DART+ West Railway Order

Dublin City to Maynooth and M3 Parkway

Impact on Gowan Group Limited

23088-TNT-XX-XX-RP-T-00001

Figure 14.0 Extract of proposed site plan relating to our clients' premises.

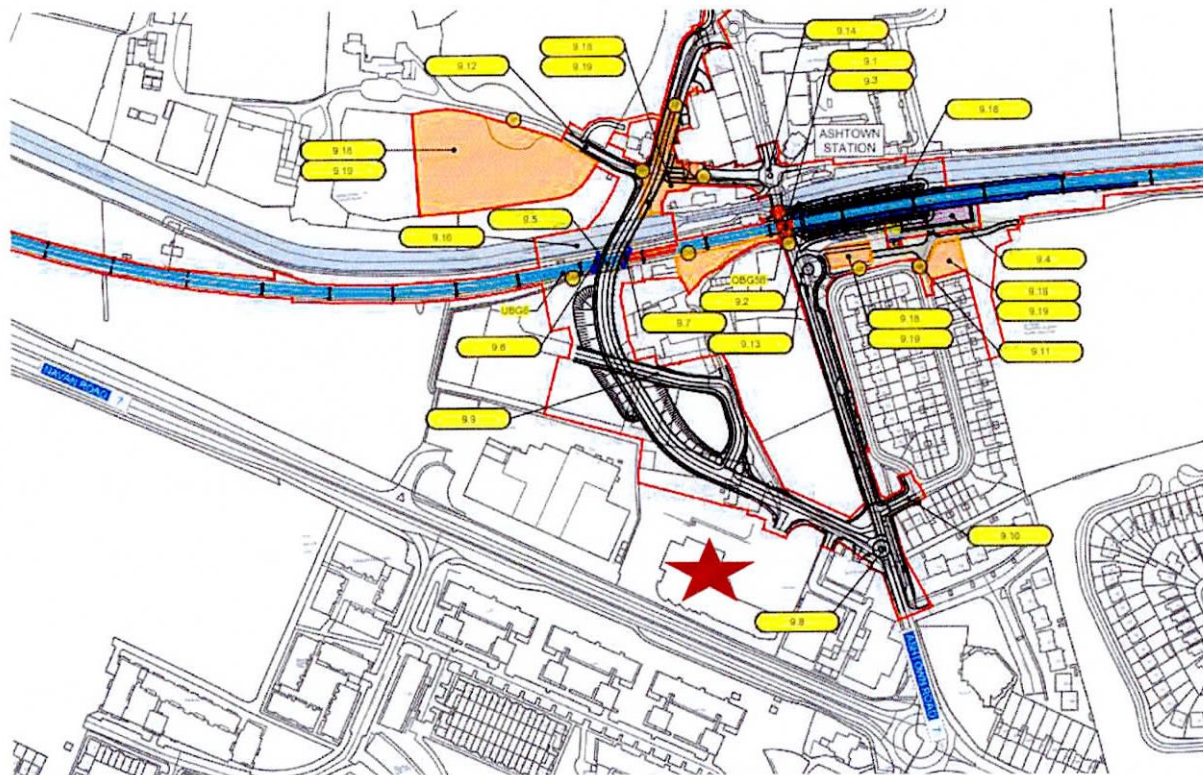
Figure 3.1 provides a visual representation of the proposed changes to the access and 3.2 demonstrates the knock on loss of on-site parking for our client

It is imperative to recognize the heavy reliance of the facility on the existing car parking/storage arrangement, which is already operating at full capacity. Any alteration to the land available will have severe implications for the facility's ability to maintain its on site operations and existing customer experience.

Figure 6.0 illustrates the necessary changes our client requires to ensure smooth operations. Failing to address these modifications may result in highly negative visitor experiences, which pose a real risk of a drop in customer numbers and in turn revenue. Our client cannot accept this for any duration during construction.

The DART+ West proposed layout results in four entrances/Priority junctions off the proposed new road. Two of these entrances are within very close proximity to the roundabout and have the potential to create confusion and, in turn, a traffic hazard. The proposed layout consolidates the three entrances into a single access onto the new road. This move see the traffic hazard associated with the car park entrance immediately adjacent to the roundabout being removed.

The roundabout is pushed further north towards the Martin Savage Park Entrance. The existing Mill Lane access to Ashtown Road is closed off and redirected to the new roundabout. The remaining section of Mill Lane is maintained as a cul-de-sac at each end, allowing for ease of access and egress for all businesses that currently have direct access off Mill Lane.

The proposed road links from this revised roundabout location to the rail/canal crossing as per the DART+ West crossing point. This alignment means no land take from Gowan and indeed more usable land for Burke's.
